**CITY OF PORTLAND, MAINE
DEVELOPMENT REVIEW APPLICATION
PLANNING DEPARTMENT PROCESSING FORM
DRC Copy**

2004-0217

Project Name/Description

RE: Joseph Avenue - 172-F-001, 002, 003 - R-3 zone - new single family dwelling - permit application #04-1585

BOUNDARY SURVEY

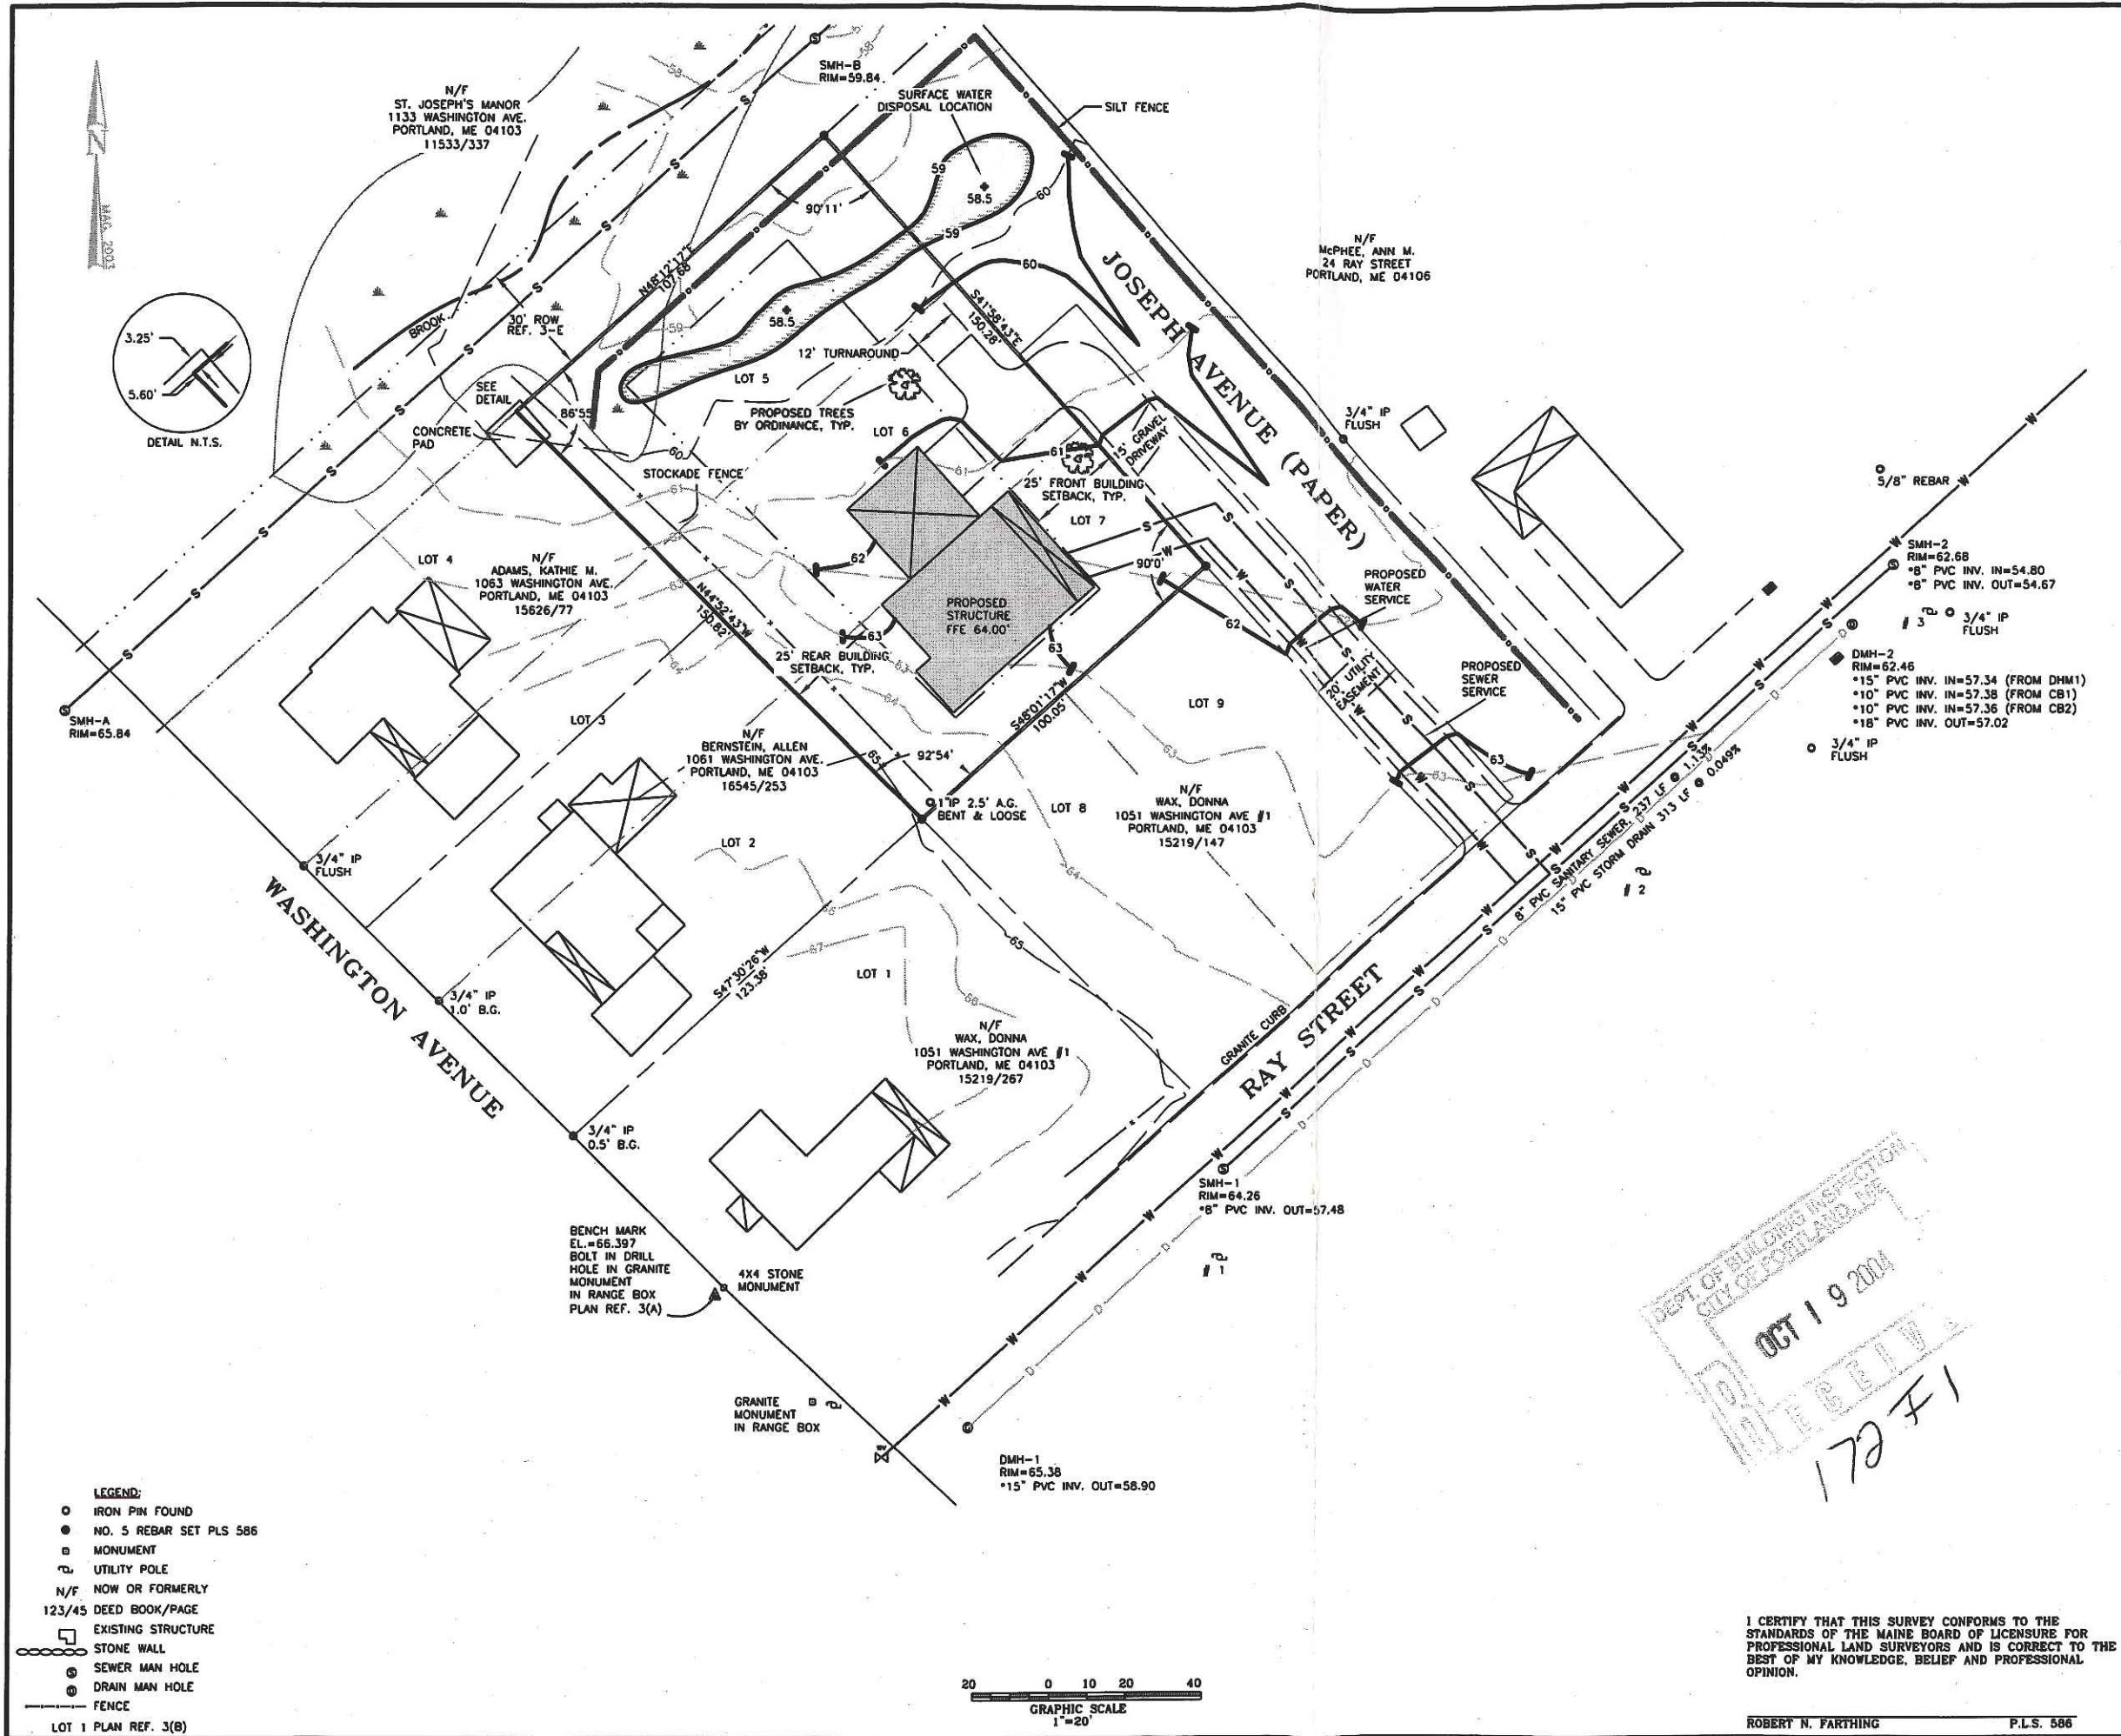
First, your site plan does not match your building plans. All dimensions shall match before a permit application can be adequately reviewed. It is also noted that there is a rear sliding door with no rear deck or stairs being provided. ALL structures that are to be approved as part of this permit application SHALL be shown on both the site plan and the structural plans.

Secondly, Joseph Avenue is a paper street as designated on your submitted plans. Section 14-403 of the ordinance states that the construction of a new housed shall trigger the requirement to upgrade the street to City standards. There is only one exception that this office has not received from you. Section 14-403 states, "The provisions of this subsection (b) shall not apply to the erection of any single-family dwelling on any lot where the owner of the lot establishes that he or she was the owner of that same lot on November 19, 1984, and at all times thereafter, and states his or her intention under oath to make the structure his or her personal residence". Your application submittal did not include such an affidavit. If you believe that all sections of the exemption allowance pertain to your application, it will be necessary to submit an appropriate affidavit to this office. If you cannot meet the requirements of the exemption, it will be necessary to show this office how Joseph Avenue is being brought up to City standards with the appropriate drawings.
